**Re: 2-6 Hassall Street, Parramatta – Response to Submissions**

I refer to the Site at 2-6 Hassall Street, Parramatta and the Submissions received from City of Parramatta Council (Council) and Transport for New South Wales (TfNSW), regarding the State Significant Development 9670 for the Western Sydney University Innovation Hub (Proposal).

1 SERVICES PLAN - PD HASSALL STREET  
1:200

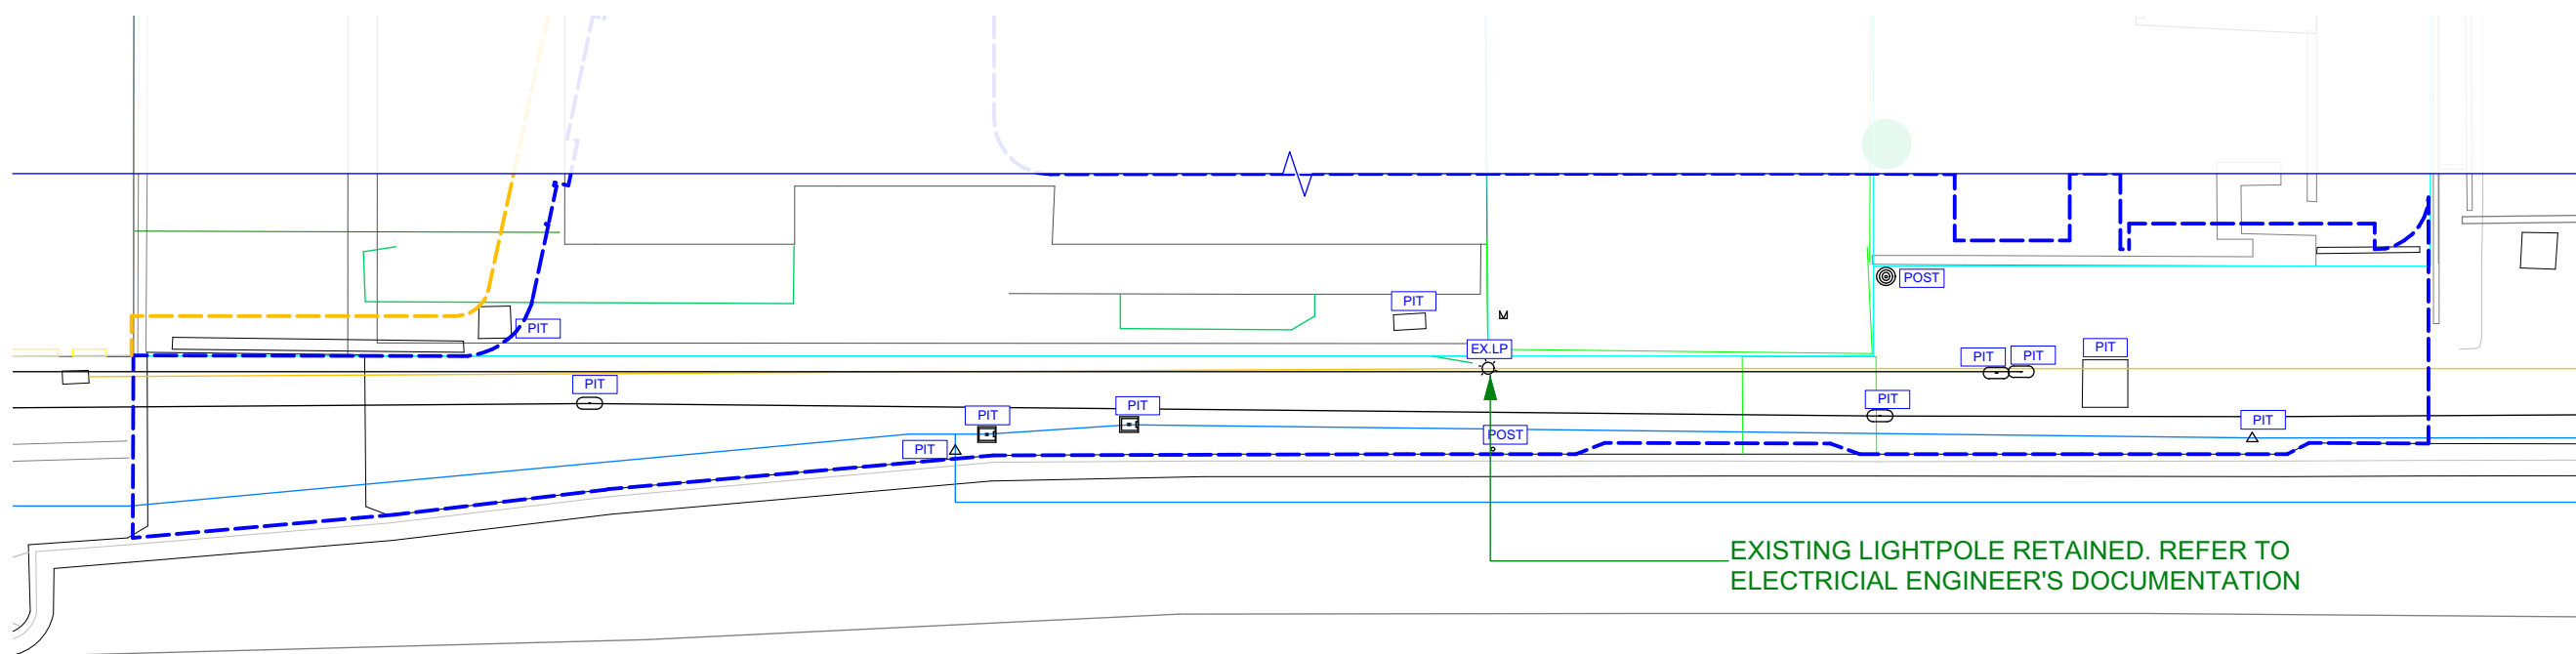
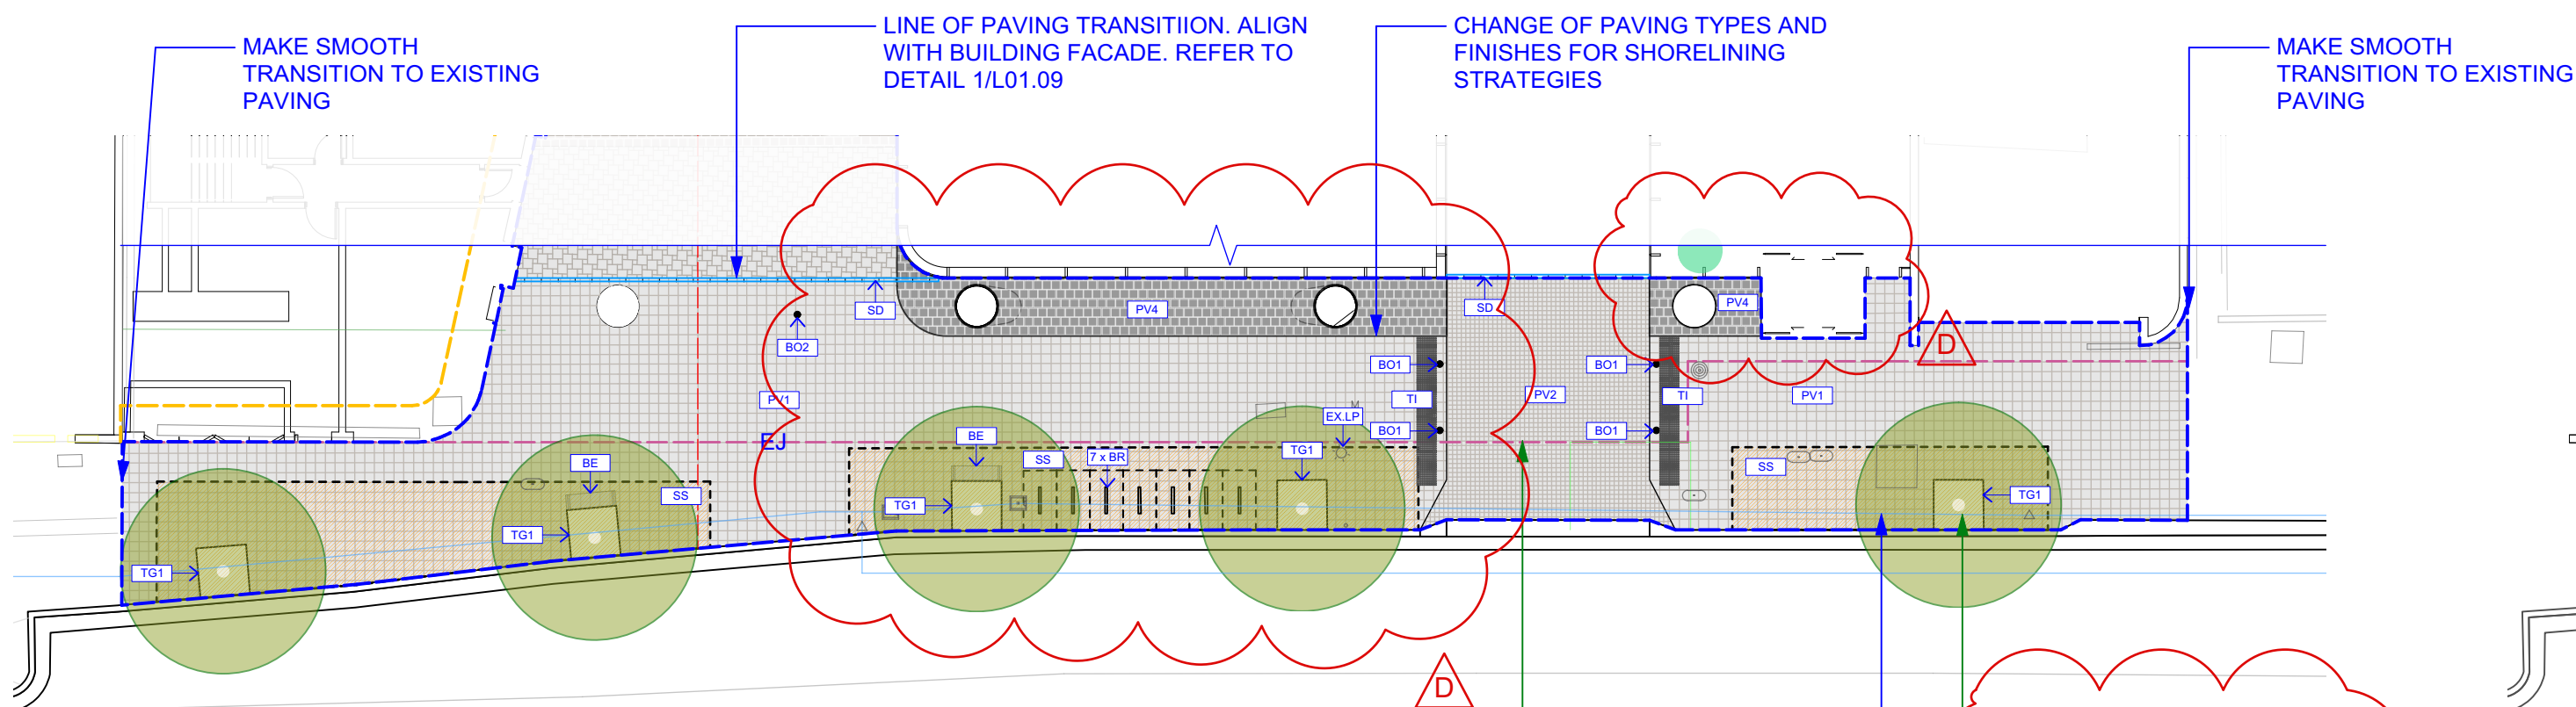
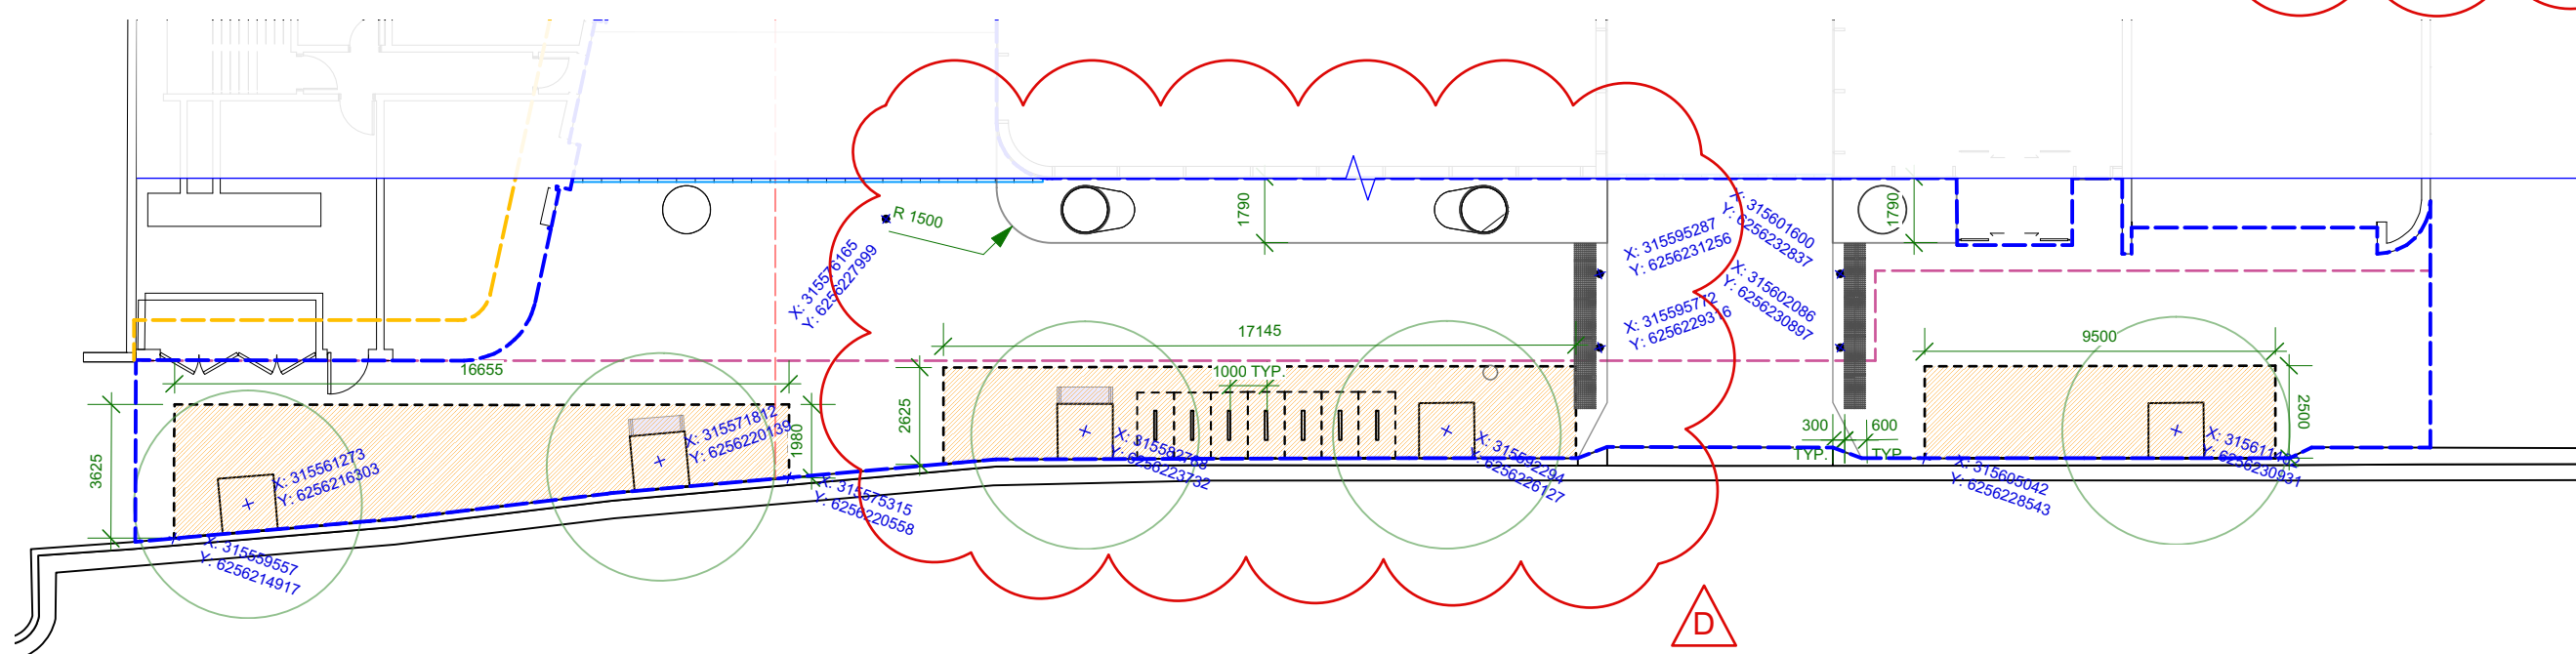
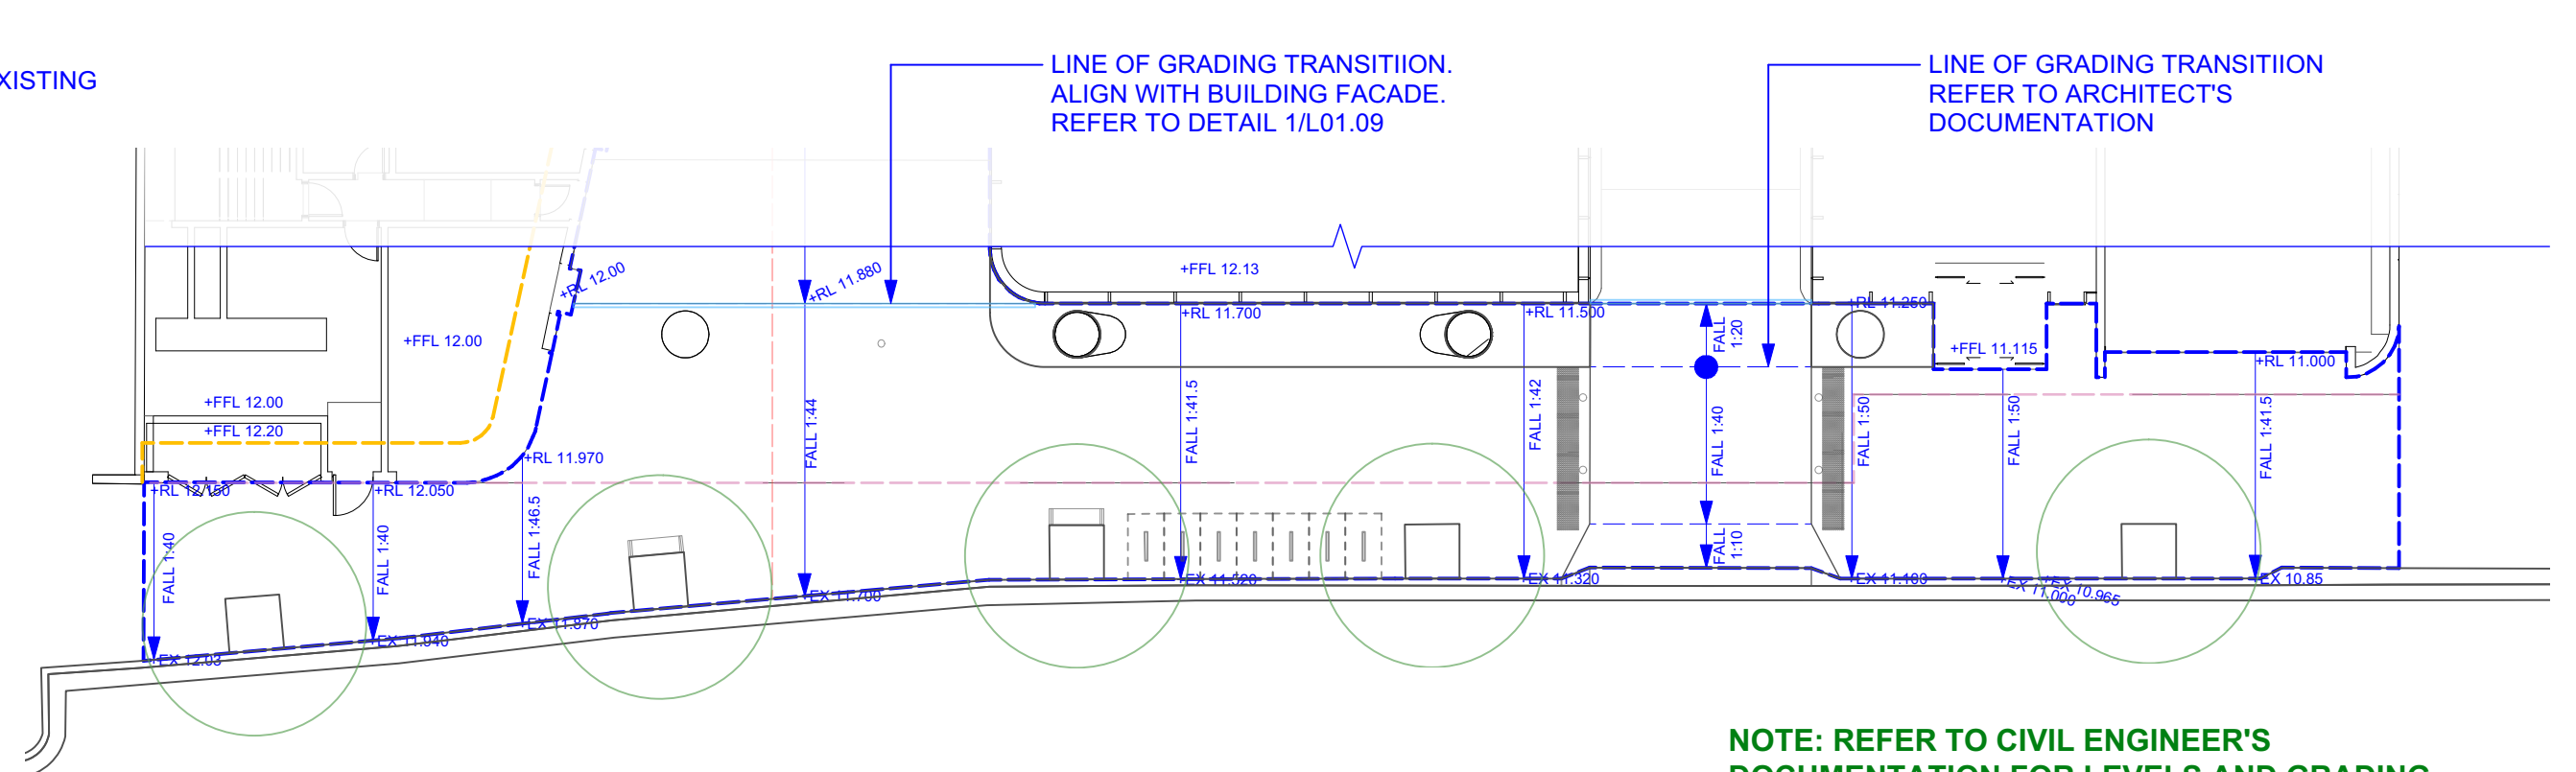
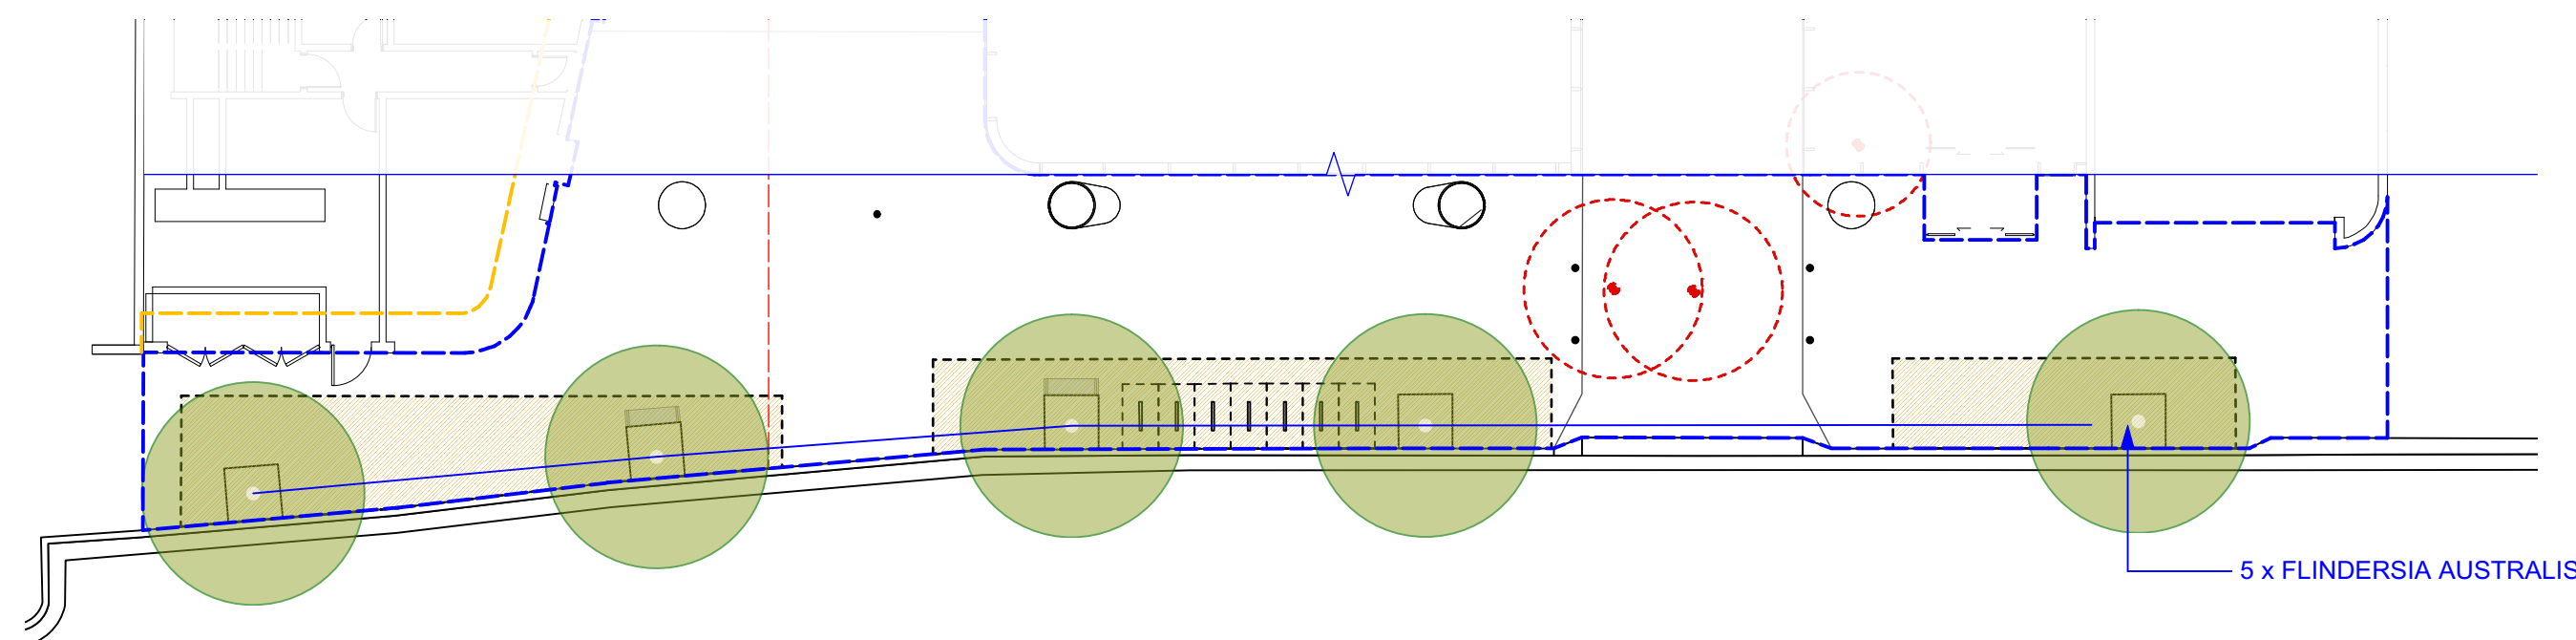
*The bollards shown at the driveway crossover of Hassall street footpath are not recommended. These should be replaced with warning TGSIs.*

These bollards have been provided to ensure the required sight splays are achieved for appropriate driver visibility of pedestrians walking across the driveway, in compliance with Figure 3.3 of AS2890.1. It is necessary to ensure that pedestrians do not occupy this area, therefore it is deemed appropriate to provide a physical barrier in this location to prioritise pedestrian safety.
